**M1 Pacific Motorway extension to Raymond Terrace (SSI 7319)
Advice on the Environmental Impact Statement (EIS)**

Thank you for the request for advice from Public Authority Consultation (PAE-24749572), requesting the review by the NSW Environment Protection Authority (EPA) of the Environmental Impact Statement (EIS) for the proposed M1 Pacific Motorway extension to Raymond Terrace (Application SSI-7319).

ATTACHMENT A: EPA COMMENT ON EIS FOR M1 PACIFIC MOTORWAY EXTENSION TO RAYMOND TERRACE (SSI 7319)

Location: L18 - Tarro Interchange, Tarro

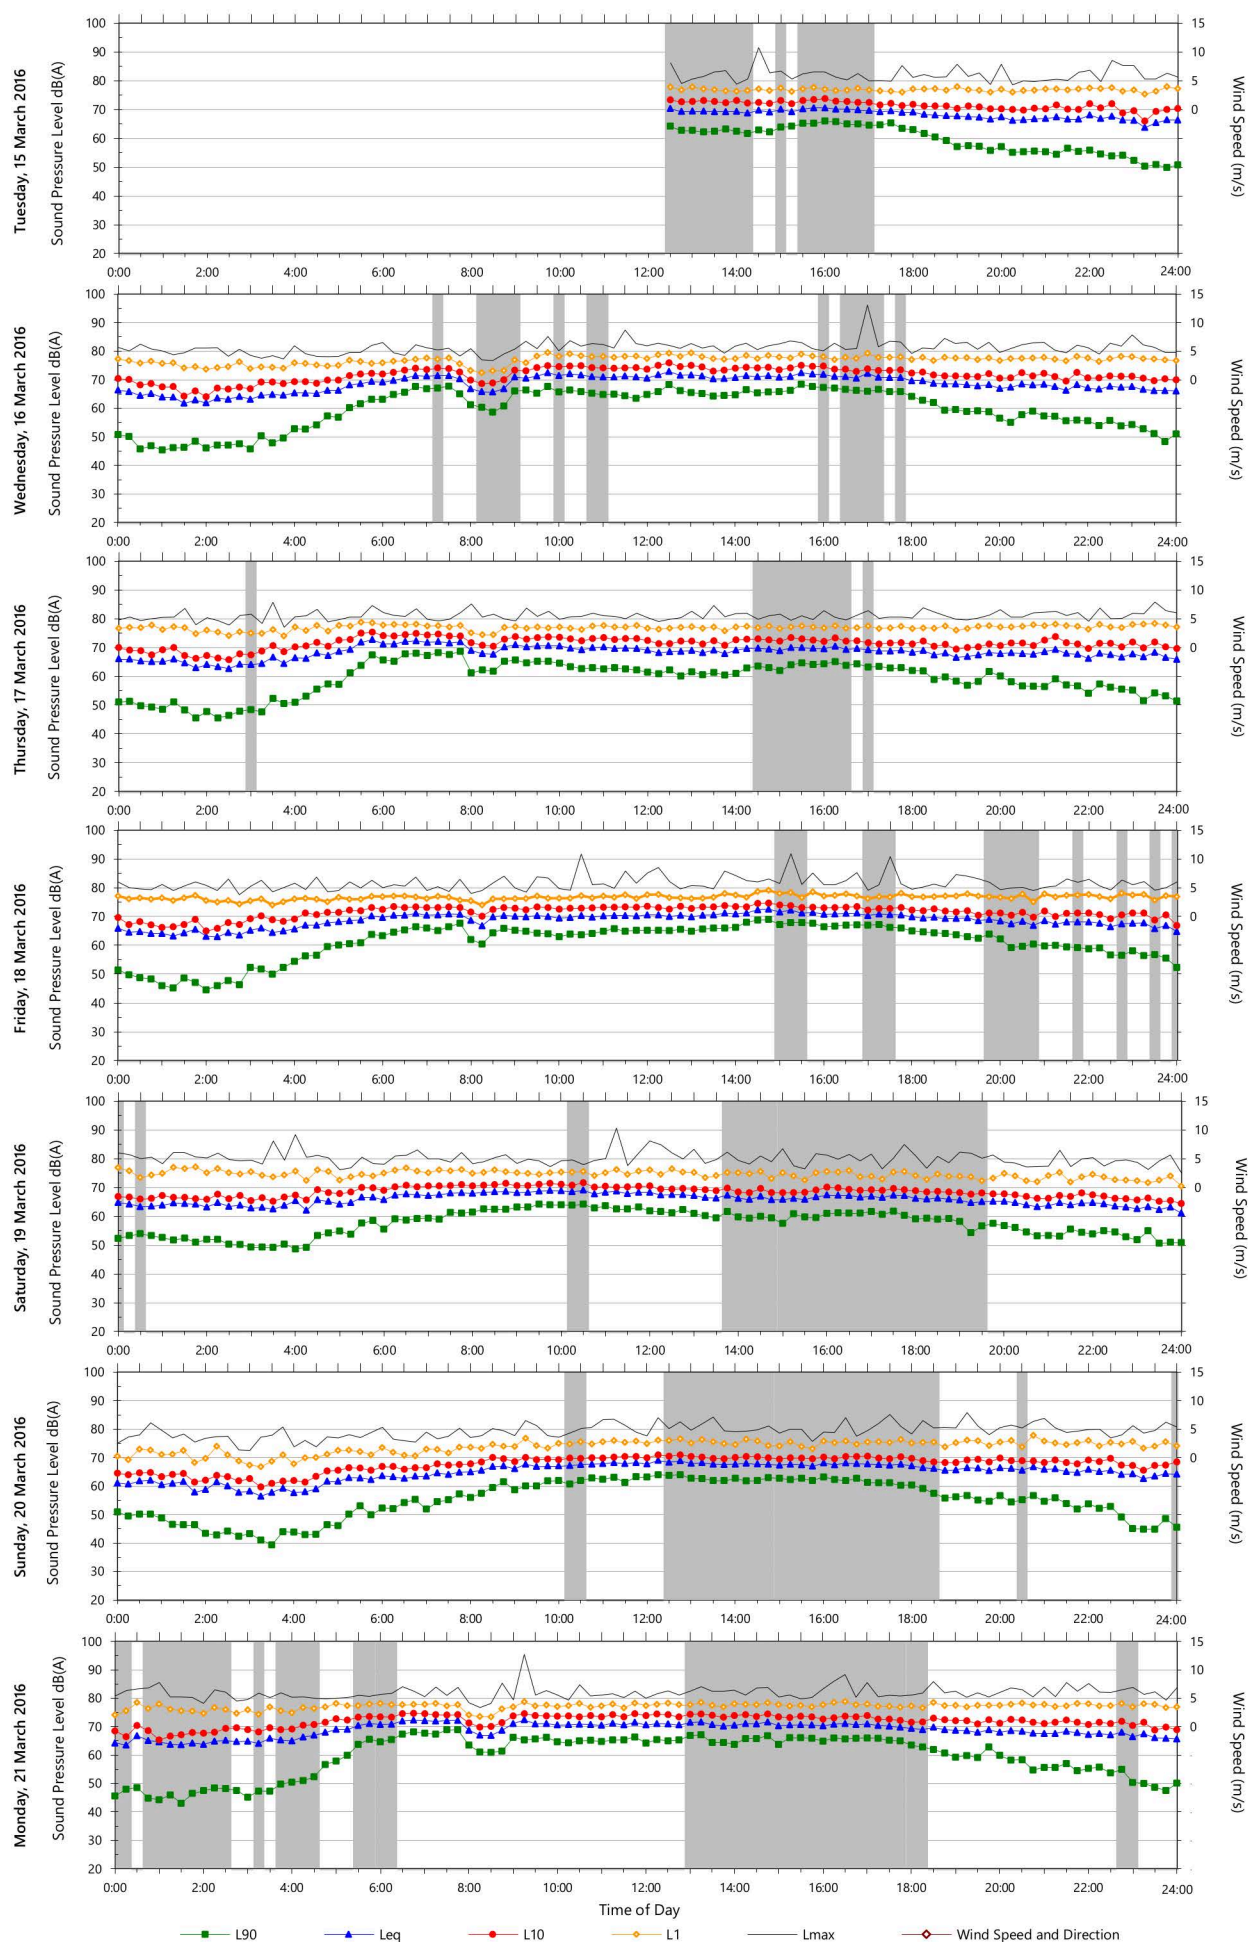
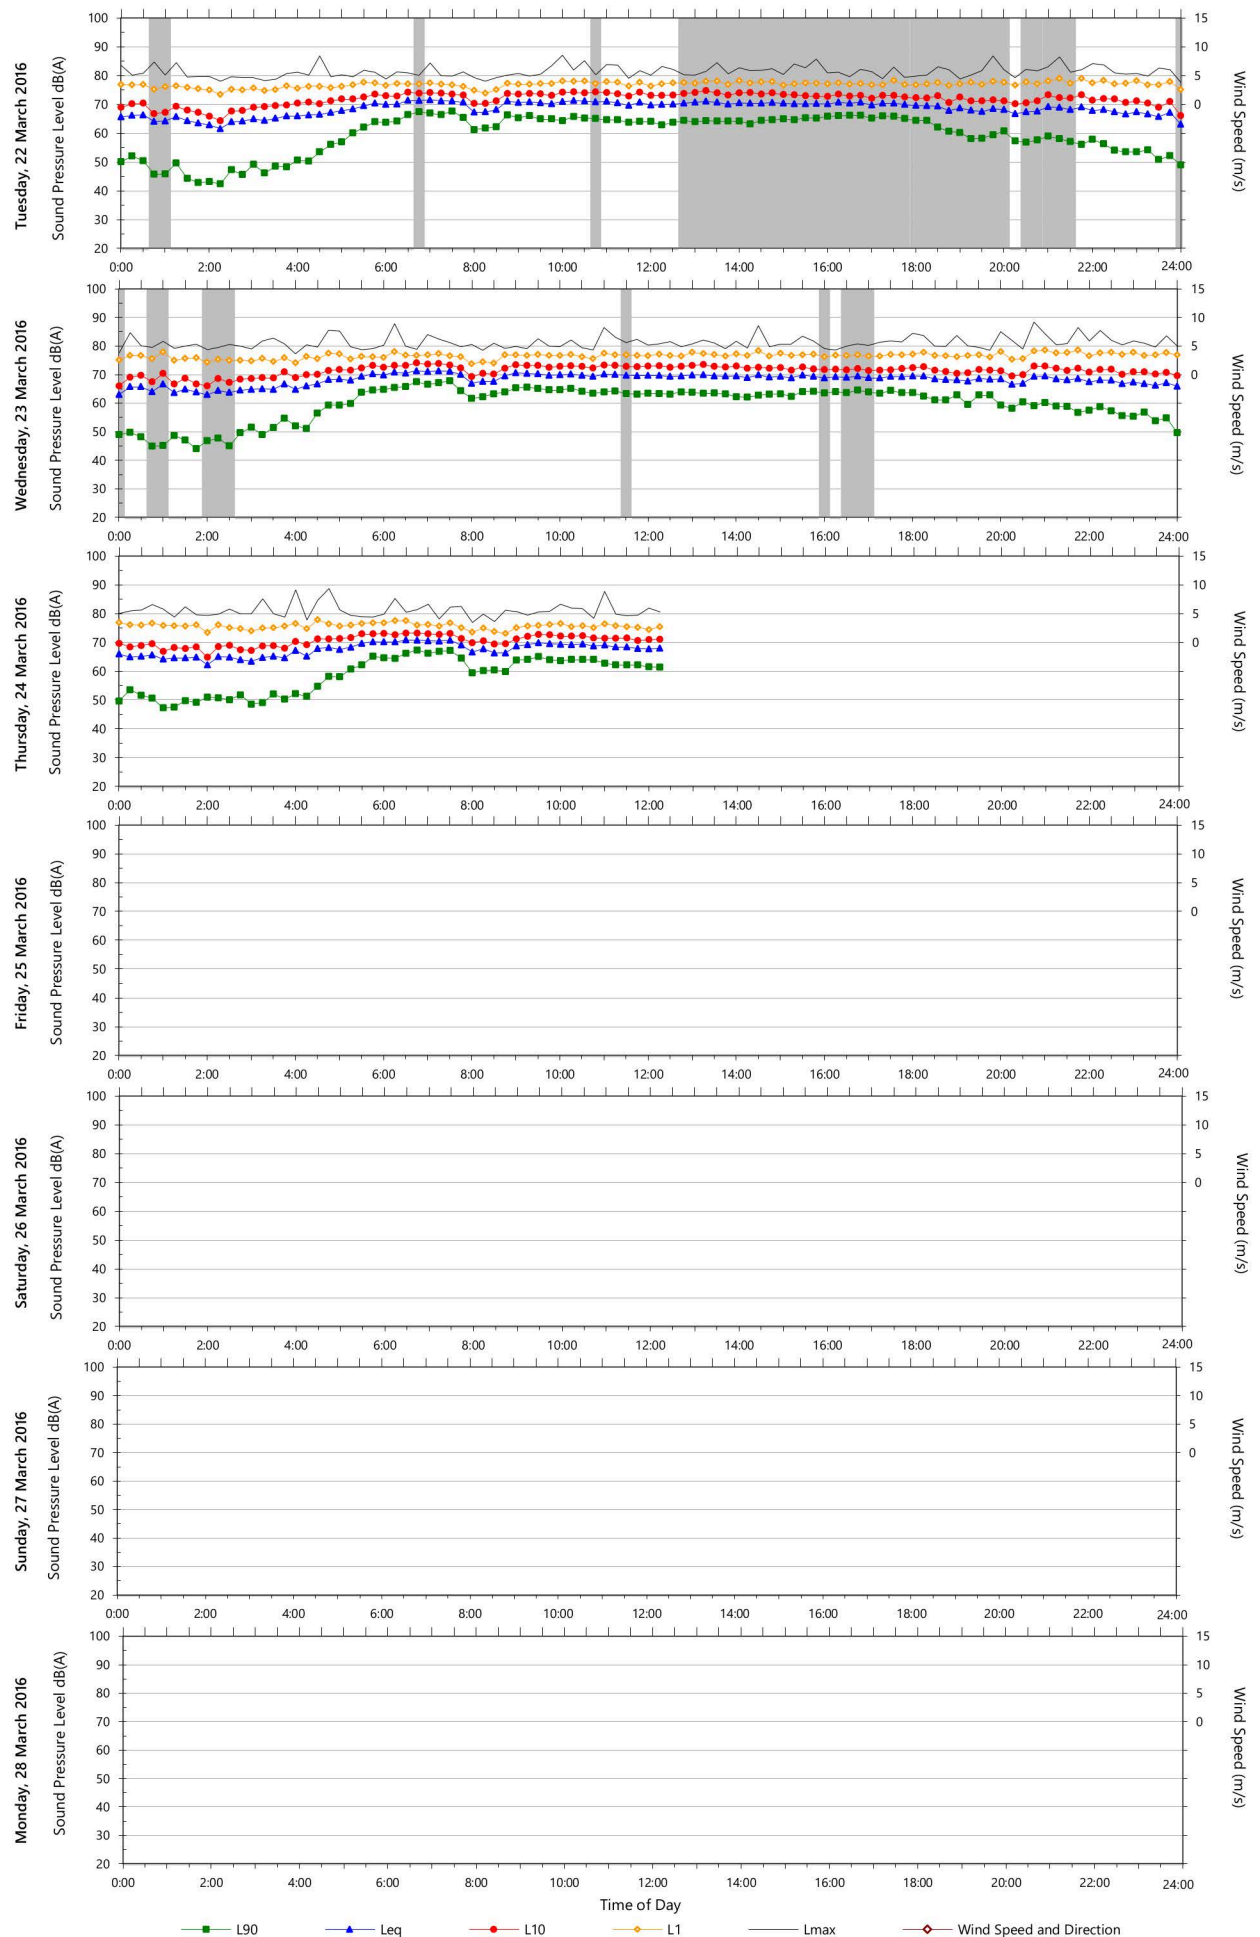
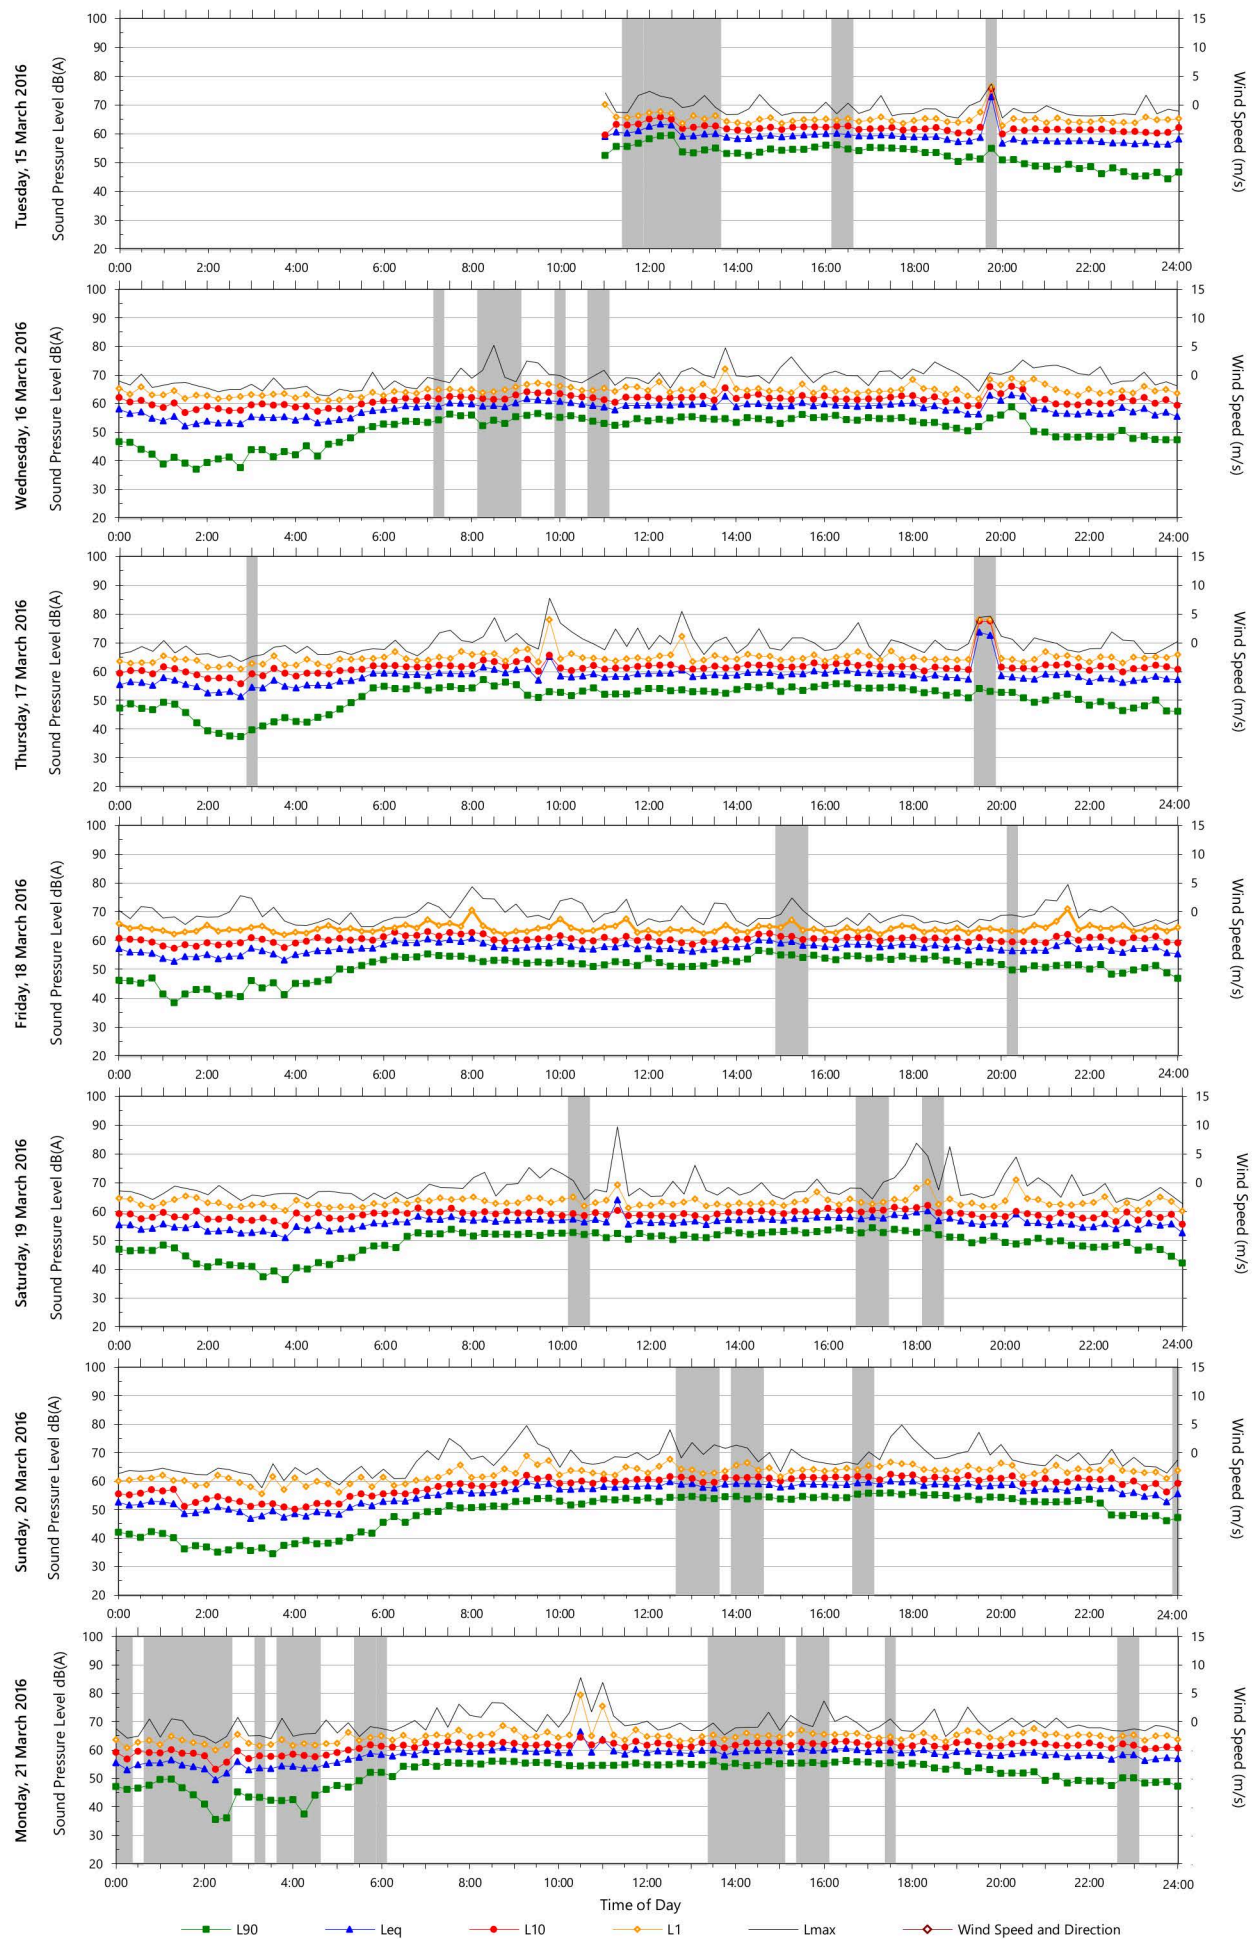
Locations L01 to L014 (inclusive) appear to have no more than 5 and in some cases less than 3 valid periods out of the total monitoring duration. Locations L15 to L20 appear to be less affected, however there it is still not clear if sufficient valid data has been presented.

Noise monitoring was also conducted in 2016 for the purposes of measuring road traffic noise. Due to the amount of data excluded at Locations L13 to L20, further justification is needed that the remaining data, after invalid samples were excluded, provides sufficient amount of data to enable a representative calculation of the traffic noise descriptors.

The proponent reviews the noise monitoring data in the NIA in the context of the monitoring requirements set out in the NPfI and for each location and either:

- Provide a justification and demonstrate that the requirements of the NPfl have been fulfilled; or
- Provide additional data that fulfills the monitoring requirements in the NPfl.

The EPA also recommends that the proponent either:

- Provides justification and demonstrate that the data presented for road traffic noise descriptors is sufficient to be representative; or
- Provides additional valid data.
